ADC PARKS & GREENSPACE ARBORICULTURE

PLANNING APPLICATION: AW/220/15/T

ADDRESS: 1 Fishermans Walk Aldwick PO21 4BU

BRIEF DESCRIPTION: Reduce 2 No. Sycamore trees by 2.5m, reduce upper crown of 1 No. Hornbeam tree by 2.5m and reduce and shape 1 No. Silver Birch tree by 2m.

- 1) x2 Sycamore trees.
- 2) Hornbeam
- 3) Silver Birch

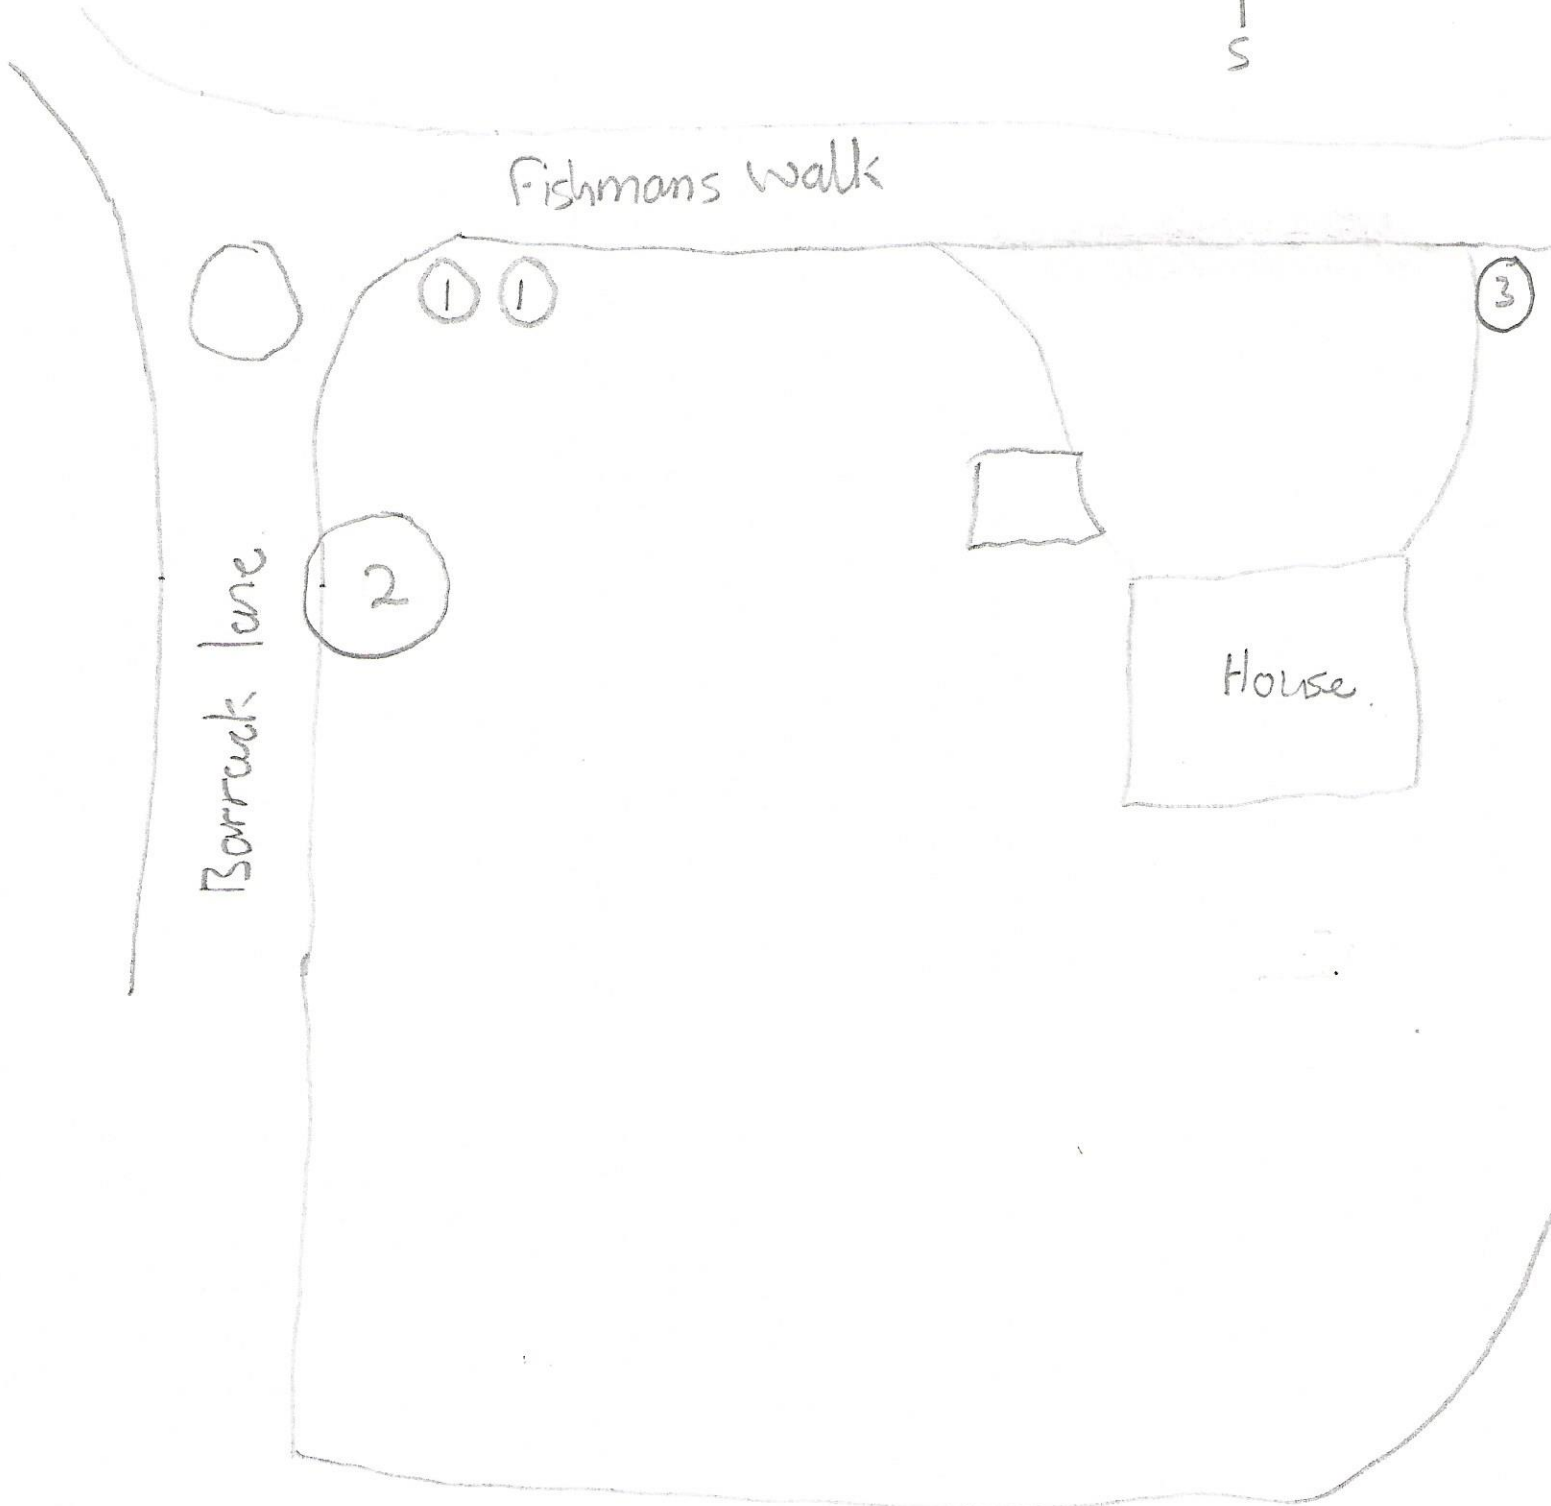
- The trees cited in this application are located in the grounds of 1 fisherman's walk.
- For **T1** and **T2**, the applicant has applied to reduce the crowns by 2.5 meters. From the site inspection **T1** and **T2** are both exhibiting evidence to suggest it has had previous reduction/s. These previous reductions emulate the applied for reductions.
- For **T3**, the applicant has applied to reduce the crown by 2.5 meters. From the site inspection **T3** does have evidence to suggest it has had

previous reduction/s. These previous reductions emulate the applied for reductions.

- For **T4**, the applicant has applied to reduce by 2 meters. From the site inspection it is apparent that **T4** has received previous reductions. **T4** is not subject to a TPO order.

- **I would have no objection to the proposed reduction to T4 of a reduction of no more than 2 meters. As T4 is not subject to a TPO order, no conditions will be required.**
- **I would have no objection to the proposed reduction to T1 – T3, of a crown reduction of no more than 2.5 meters. As T1 – T3 are covered by active TPO orders, the following conditions must be adhered to;**

All side branches to be retained should be at least **1/3rd** in diameter of the removed branch. Pruning cuts must be flat and smooth, kept as small as possible by cutting at an optimum angle and should not exceed **100mm** in diameter.

The Crown Clean should consist of deadwood and stub removal where all cuts should be made to the branch collar. Where crossing branches are encountered the weaker branch/branches should be reduced or removed to avoid contact between them. The remaining branch/branches should be shortened as appropriate to relieve 'end weight' and sudden exposure by reducing the leaf bearing branch tips by no more than 30%.
